# MONA OFFSHORE WIND PROJECT

## Response to Griff Parry on behalf of Harriet Mary Parry, Robert Wynne Parry, Griffith Wynne Parry and Elizabeth Wynne Wade D2 Submission

Application Reference: EN010137

Document Number: MOCNS-J3303-RPS-10307

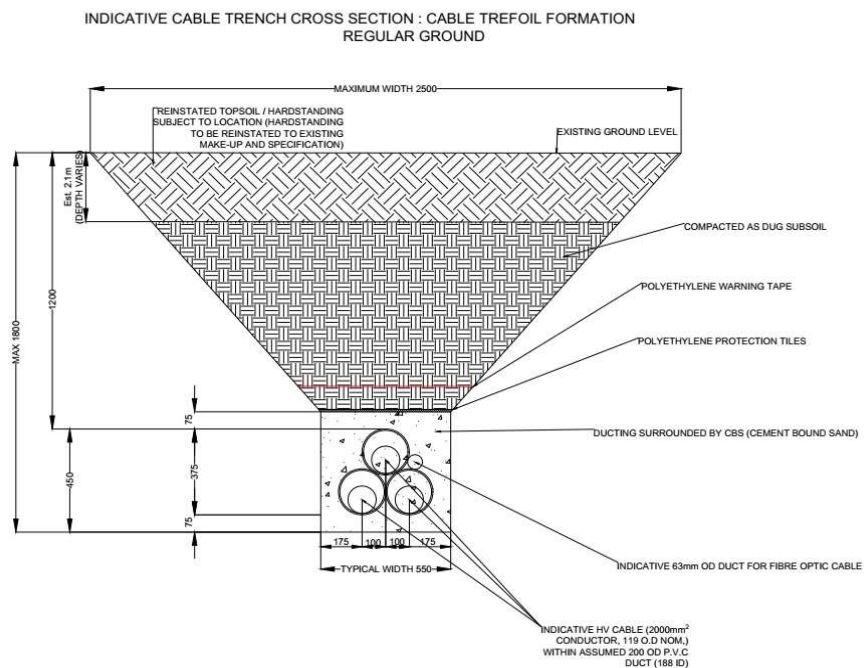
Reference	Written Submission Comment	Applicant's response
REP2-102.10	3.2 The Promoter intends an excavation down to approximately 1.8m with the cables being laid on top of circa 75mm trench bedding (i.e. the bottom of the cable duct will sit at 1.725m depth). Minimum depth of cover over the upper cable is intended to be 1.2m.	
REP2-102.11	<p><b>Trench Width, Support and Safety issues</b></p> <p>3.3 "Prescriptive" Health and Safety Executive ("HSE") regulations dating from 1966 used to adhere to a presumptive rule that if a trench excavation was under 1.2m in depth then it did not need trench support. Later it was realised that, despite earlier guidance, there were actually considerable Health and Safety issues with trench excavations up to 1.2M and so the position was not endorsed in subsequent HSE advice.</p>	<p>As stated with the Project Description (APP-050) and shown on the indicative cross-section issued at Deadline 1 (REP1-018), the maximum trench width at surface is 2.5 m and the maximum trench width at base is 1.5 m. This allows for either a flat or trefoil cable formation of ducts within the trench excavation.</p>

REP2-102.15 3.7 The drawing is clearly marked “not to scale” and so the Promoters proposed angulation for the excavation cannot be reliably measured. There also seem to be some discrepancies with the Promoter’s vertical measurements on the diagram which make calculating the angle a little more difficult. Nevertheless, with some margin for error, the angle has been estimated to be approximately 52.5 degrees from the horizontal.

REP2-102.17 3.9 Nevertheless, based on the standard arrangement described in the Hearing Action Point Submission, it can be seen that after the first 1.275m of the trench walls will be battered at an angle of approximately 52.5 degrees. This causes the open trench

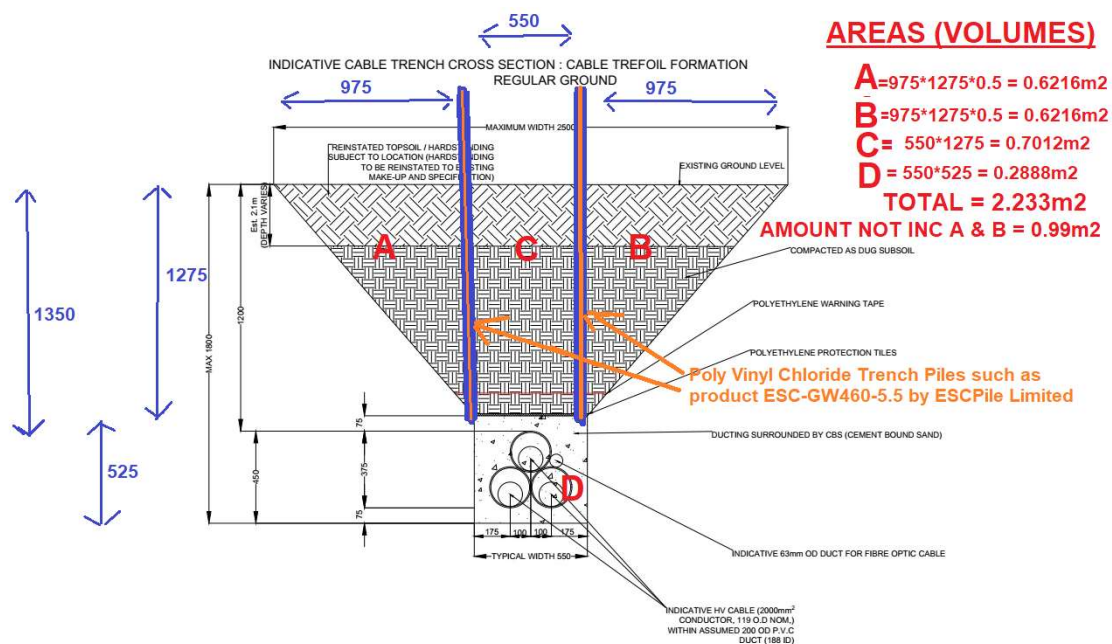
REP2-102.18 3.10 Notwithstanding the health and safety risks, this gives rise to a great deal of additional excavation and material arisings than would otherwise be required and this is calculated in the markup below:

REP2-102.19 3.11 Areas A,B,C and D amount to approximately 2.233m<sup>2</sup>. For each linear metre of the cables the volume of spoil being removed would therefore be 2.233m<sup>3</sup>.

REP2-102.20 3.12 If however, trench sheets were used allowing straight vertical walls to the trench then a more proportionate rectangular trench of only 0.99m<sup>2</sup> would be affected or a volume of 0.99m<sup>3</sup> for each linear meter of the trench.

REP2-102.21 3.13 In addition to the saving of substantial volume excavated then this would also mean that 2 metres per trench could be saved off the temporary working area. This would be 8m over the 4 trenches.

The Applicant would emphasise that the cross sections provided at Deadline 1 (REP1-018) are indicative and state that they should not be

Reference	Written Submission Comment	Applicant's response
	3.14 For the following purposes we ignore any separation between topsoil and subsoil (which varies in depth from site to site in any event) and just deal with overall volumes.	<p>used for scaling. They have been provided to give an example of how the proposed trenches would be accommodated within the Onshore Cable Corridor. The proposed installation technique depicted on the cross sections provided is the industry standard for excavation of trenches and installation of a ducted system, for cross-country cable routes. The volume of soil to be excavated and stored at any specific location will depend on a number of factors including ground conditions and final location of joint bays and link boxes, all of which will be determined during detailed design.</p> <p>In addition, the calculations provided in the Representation do not fully assess all options presented within the Project Description (APP-050), for example, a flat formation will be up to three times the width at the base of the trench compared to the trefoil formation used in the calculations and will therefore require additional soil to be excavated.</p>

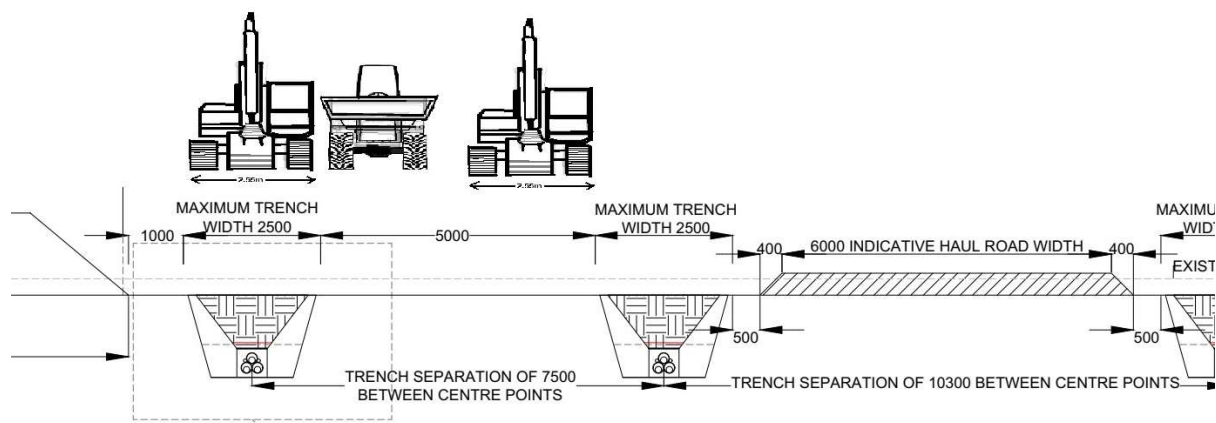
REP2-102.43	3.35 In terms of construction a standard 12 tonne tracked excavator has a width of approximately 2.55m wide. This itself is slightly more than the trench width that the Promoter intends to utilise.	<p>The Outline Highways Access Management Plan (APP-228) presents the access strategy for the Project. In order to minimise impacts of Heavy Goods Vehicle (HGV) traffic upon concentrations of sensitive receptors, the temporary construction haul road will be used where possible to avoid routeing traffic along the public highway network. Therefore, the</p>
REP2-102.44	3.36 Two excavators have therefore been shown overlaid on the Drawing below:

REP2-102.45 3.37 A tracked trenching excavator would ordinarily operate by locating itself on the line of the as yet unopened trench so that the jib was behind it and in line with the centre of the newly excavated trench to the rear of its direction of travel. The diagram shows that not only is there sufficient room for an excavator over the trench but that a further two excavators or more likely, 5 to 7 tonne dumpers (also of width circa 2.5m) or similar pieces of large excavation / muck removal equipment could be accommodated in the 5m spacing which as well is excessive and unnecessary for cable laying and accomplishment of the Scheme. This would be even more the case in the event that the narrower trenches were employed due to using more efficient and safer trench piles.

REP2-102.47 3.39 Construction reasons therefore do not justify a 5m space between trenches.

haul road is required to provide 2-way access predominantly for standard HGV movements along the entirety of the Onshore Cable Corridor.

The haul road has been indicatively shown centrally within the Onshore Cable Corridor, as shown on the indicative cross-section issued at Deadline 1 (REP1-018), as this approach minimises the amount of construction traffic movements on the subsoils and is typically used on other cross-country cable route projects. The haul road width and location within the cable corridor will be confirmed during the detailed design stage and will be influenced by topography and existing ground conditions.

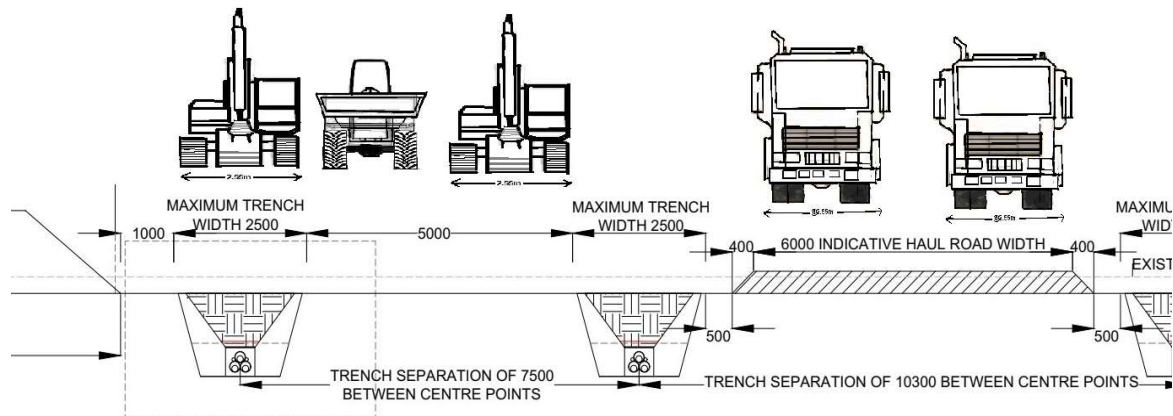
REP2-102.50 **6 metres haul road down the centre of the permanent easement area**  
3.42 A standard 4 axle rigid 32 tonne tipper also has a width of approximately 2.55m wide. This again itself is slightly more than the trench width that the Promoter intends to utilise.

REP2-102.51 3.43 Two such tipper wagons have therefore been shown overlaid to on an extract from Drawing below which shows that the road can conveniently accommodate two way Heavy Goods Vehicle traffic:
